Cottam Solar Project

Statement of Common Ground (FINAL) Historic England

PINS Ref: EN010133
Document reference: EX5/C8.3.4_A
Infrastructure Planning (Examination Procedure) Rules 2010

Drawing file: EN010133 / EN010133-001020-C6.4.8.16.7.2_A Figure 8.16.7.2 Landscape and Ecology Mitigation and Enhancement Plan - Cottam 1_West_Option B_Sheet 3.pdf

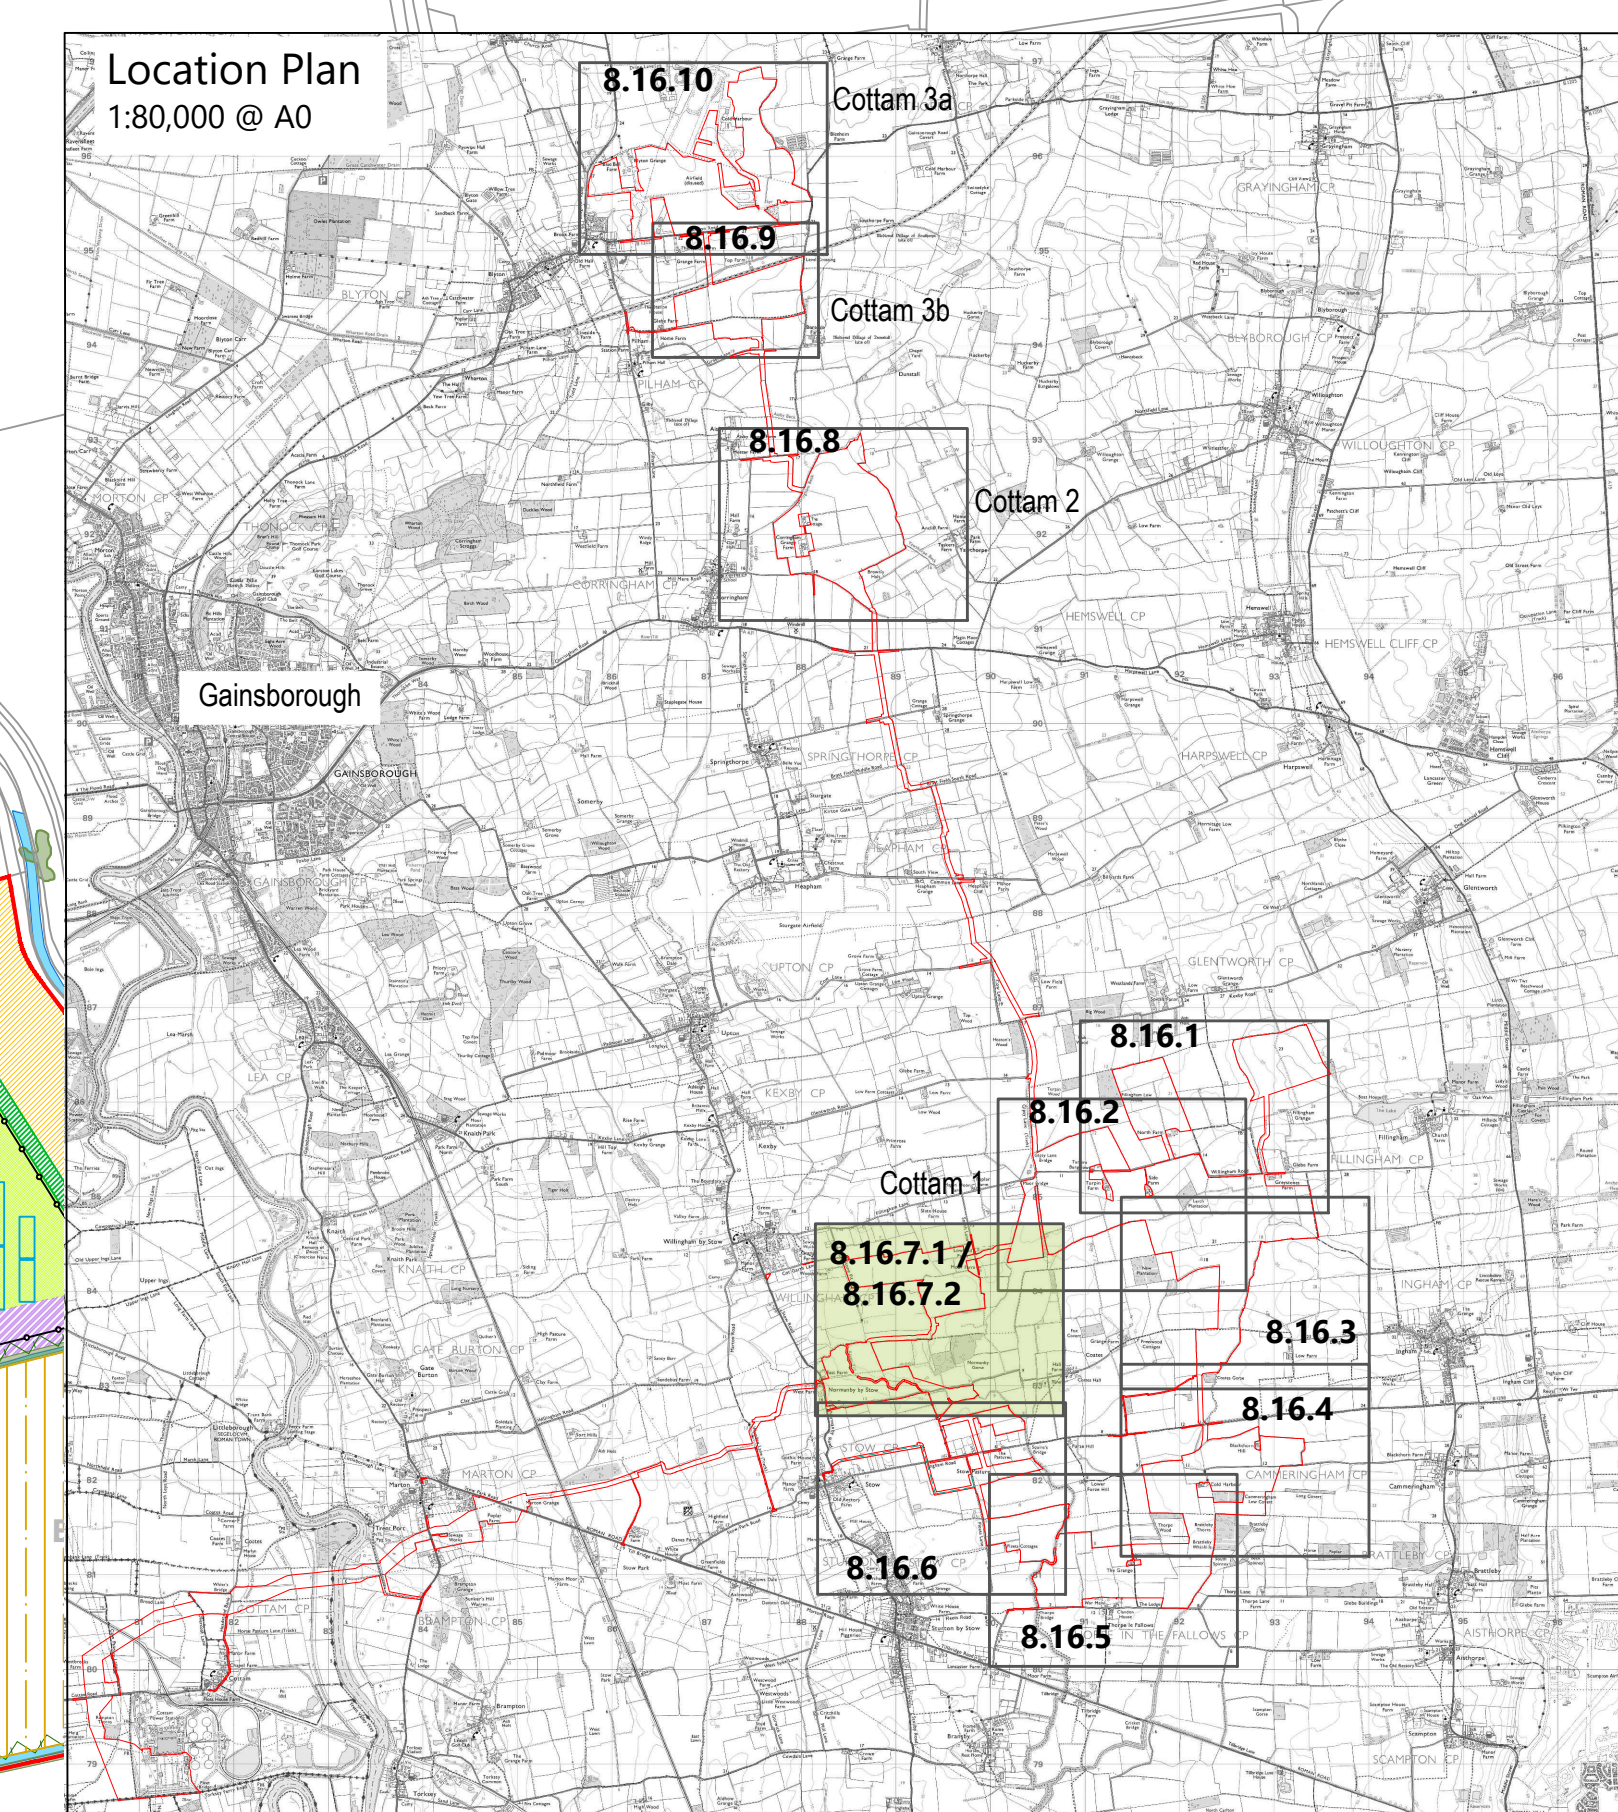
<p>HE considers the 50m buffer between the Thorpe in the Fallows shrunken Medieval Village (SMV) Scheduled Monument (1016978) and the solar panels is insufficient and does not address the impacts caused by the Scheme to the significance of the monument. HE recommends that the panels are removed between the SMV and a former historic east-west boundary recorded on the 1886 25-inch Ordnance Survey (OS) map (approximately along the line of grid points: SK90976 80920, SK91149 80944, SK91330 80904 and SK91351 80909). HE also stated that the design of the Scheme should look to recreate the character of the former field boundary i.e. a new hedgerow is planted along the rough course of the field boundary as recorded on the 1886 OS map.</p> <p>The Applicant explained their understanding of the relationship between the Thorpe in the Fallows SMV and the field to the north of the SMV. Namely, the SMV derives significance from the visual relationship with the fossilised medieval field boundaries that form the east and west boundaries of the field in question. Additionally, the SMV draws significance from the agricultural character of the open field, as historically the field would have formed an element of the agricultural land cultivated by the residents of Thorpe in the Fallows. The Heritage Statement has established the proposals will obscure views of the fossilised field boundaries and have an industrialising effect on the character of the field. The proposed 50m set back is intended to provide a buffer zone that illustrates the distinction between the SMV and the solar farm as well as providing a strip of land that illustrates the agricultural character of the field. The proposed set back will not avoid obscuring the fossilised field boundaries or having an industrialising effect on the character of the field. The Applicant believes the current proposed set back will achieve its intended aims. The increased set back suggested by HE will also provide a buffer and illustrate the historical agricultural nature of the field, but to no greater extent than the 50m set back and the increased set back would still obscure views of the fossilised field boundaries from the SMV as well as having an industrialising effect on the character of the field.</p> <p>The Applicant then enquired to HE's reasoning for off setting panels to the former east-west field boundary recorded on 19th-century historical maps, as desk-based research undertaken by the Applicant has demonstrated that there is no direct historical relationship between the scheduled Thorpe in the Fallows SMV and the east-west field boundary. During the medieval</p>

Topic	Sub-topic	Details of Matters Not Agreed
<p>HE-2</p> <p>Approach to safeguarding designated heritage assets</p>	<p>Scheduled Monument Thorpe medieval settlement (NHLE ref 1016978)</p>	<p>HE and the Applicant are not in agreement as to appropriate mitigation of setting impacts upon the significance of Thorpe medieval settlement, a scheduled monument.</p> <p>HE is in agreement with the Applicant that the potential impact of the Scheme on the setting of Scheduled Monument Thorpe medieval settlement (NHLE ref 1016978), as identified in ES Chapter 13 [APP-048], is ‘moderate adverse’ – ‘significant’, which equates to less than substantial harm using NPS/NPPF classification.</p> <p>To mitigate against any potential impacts to the setting of Thorpe medieval settlement (NHLE ref 1016978), and in response to comments by HE during a site visit on 13.05.2022, the proposed development has been offset c.50m from the northern edge of the Scheduled Monument. In addition, a hedgerow is proposed to be located to the north of Thorpe in the Fallows to provide screening between the village and the Scheme.</p> <p>HE considers the 50m buffer is insufficient and does not address the impacts caused by the Scheme to the significance of the monument. HE recommends that the panels are removed between the SMV and a former historic east-west boundary recorded on the 1886 25-inch Ordnance Survey (OS) map (approximately along the line of grid points: SK90976 80920, SK91149 80944, SK91330 80904 and SK91351 80909). The design of the Scheme should look to recreate the character of the former field boundary. HE has stated the following:</p> <p><i>“The historic agrarian setting of the Thorpe le Fallows scheduled monument is important to its significance as the remains of a rural medieval settlement. Further to our rejection of the proposed c50m offset as insufficient to address the setting of the monument, we have</i></p>

<p><i>advised that this specific field boundary should be reinstated as a limit to the solar array. This former boundary has a direct historic landscape relationship to the shrunken settlement remains to its south and the rising round upon which Thorpe le Fallows sits. The irregular line of this east-west boundary as shown on the 1st edition OS 1:2500 mapping suggests it sat in an organic relationship to the pattern of open-field cultivation stripes and associated land tenure, in contrast to the straighter more regular subdivision of strips characteristic of more structured enclosure. The significance of the monument is not set in a singular medieval moment of fully open fields and peak population that can be juxtaposed to an equally static post-medieval landscape of depopulation and enclosure. Central to the understanding and appreciation of shrunken or deserted medieval villages is that the archaeological remains we encounter relate to complex and extended processes of social and economic change; sudden changes may occur but they do not define the limit of interest or understanding. Significance is therefore [diachronic] concerned with the history and evolution of the monument in this landscape rather than [synchronic] confined to certain particular points in time. We have set out a reasonable measure to conserve and better reveal the significance of the scheduled monument, and reframe it in the context of the harm resulting from development's transformation of its agrarian setting. The reinstatement of this former boundary as a limit to the solar array is both proportionate and necessary to a sustainable planning outcome. The irregular character of the boundary is important to the effectiveness of this mitigation, any functional straight-line security fencing would need therefore to sit north of the reinstated boundary. To be effective as mitigation the reinstated boundary would need to be a laid hedgerow and would benefit from the inclusion of some standard trees for instance crab apple, field maple etc."</i></p> <p>Although the Applicant appreciates HE's position that the former east-west field boundary to the north of the village is a vital aspect of the evolution of the landscape to the north of the village and so helps create a structured relationship between the of the village and it immediate hinterland, with respect to the transitional historic character of Thorpe in the Fallows (meeting dated 22.06.2023), the Applicant considers that the east-west field boundary quintessentially belongs to a post-medieval to early modern landscape characterised by small enclosed fields, which is in direct contrast to</p>

<p>period the landscape to the north of the SMV was likely to have formed large open agrarian fields. This is evidenced by the north-south orientated field boundaries running to the north of Thorpe in the Fallows SMV, which fossilise the former regimes of medieval cultivation; they have a clear reverse 'S' form indicative of medieval ridge and furrow. It can therefore be assumed that the east-west field boundary to the north of Thorpe in the Fallows post-dates the medieval village, and was in operation from post-medieval period until its removal during the second half of the 20th century.</p> <p>HE is of the opinion that by siting solar panels further away from the scheduled area, it would also reduce their prominence and therefore impact to the setting of the SMV. Their view was that the field boundary supplements the evolutionary history of the Thorpe in the Fallows Scheduled Monument as there is a structural relationship between the SMV and the transitional historic landscape to its north. Therefore, although the field boundary post-dates the medieval village, it helps to enhance the transitional historical setting of the SMV and allows the scheduled monument to be experienced in a more structured way.</p> <p>The Applicant believes that by removing panels between Thorpe in the Fallows and the former location of the east-west field boundary to the north of the village, as depicted on the 1886 OS map, the Scheme is respecting a post-medieval landscape, the setting and character of which are distinctly separate to the SMV and its immediate hinterland. By recreating the character of the field boundary recorded on the 1886 OS map, the Applicant believes there is the potential to alter the character of the setting of the medieval village, which would have been formed of large open fields, and consequently misrepresent the experience of the medieval village. It can be noted that only minor evidence of the field boundary was identified during the field evaluation. Geophysical survey identified a fragmented and dispersed series of anomalies suggestive that the feature had been ploughed out. Two evaluation trenches were targeted on the field boundary, based on historic maps and anomalies identified through the geophysical survey, but failed to identify any associated remains. This may be suggestive that as well as being transient within the post-medieval period, it was also of a relatively shallow construction.</p> <p>The Applicant also highlighted the temporary nature of the Scheme, as following decommissioning, the fields can be returned to their present state. The recreation of the former</p>

east-west field boundary would be problematic. In isolation the field boundary has a questionable heritage value, for example there should be a preference to preserving views between the SMV and the north-south orientated field boundaries running to the north of Thorpe in the Fallows SMV, which fossilise the former regimes of medieval cultivation.
30/01/2024	Online meeting with Historic England (HE) and the Applicant.	Discussion regarding mitigation for Thorpe in the Fallows. Positions of HE and the Applicant remain unchanged.

<p>the medieval landscape which was formed by large open field systems. The scheduling of the Thorpe in the Fallows SMV pertains only to the medieval village, and so as such does not relate to the later post-medieval landscape. Therefore, the Applicant respectfully disagrees with the deduction that the former east-west field boundary contributes to the significance of the scheduled SMV, and that removing solar panels between the SMV and the field boundary would enhance the experience of the heritage asset/reduce impact. Further information detailing the Applicant's position can be found in the Applicant's Response to ExA First Written Questions (Response 1.9.9) [REP2-034], Written Summary of Applicant's Oral Submissions and Responses to Action Points at Issue Specific Hearing 2 (Agenda Item 3A) [REP3-033] and Applicant's Responses to Deadline 3A and 4 Submissions (Response 2.9.2) [EN010133/EX5/C8.1.32].</p> <p>The Applicant has calculated that the removal of the solar panels between the Thorpe medieval settlement SM and the former field boundary, as recommended by HE, would result in the loss of approximately 4.725 MWp of installed capacity and 5.5 MWh/year energy generation loss, based upon the indicative layouts that the Environmental Statement was based upon. The Applicant does however note that this figure is subject to change dependent upon future advances in technology which could increase the generating efficiency of panels.</p> <p>Historic England's most recent submission with regard to setting impacts upon Thorpe medieval settlement scheduled monument can be found at [REP4-079] Historic England Deadline 4 Submission - responses to the ExA's Second Written Questions.</p>
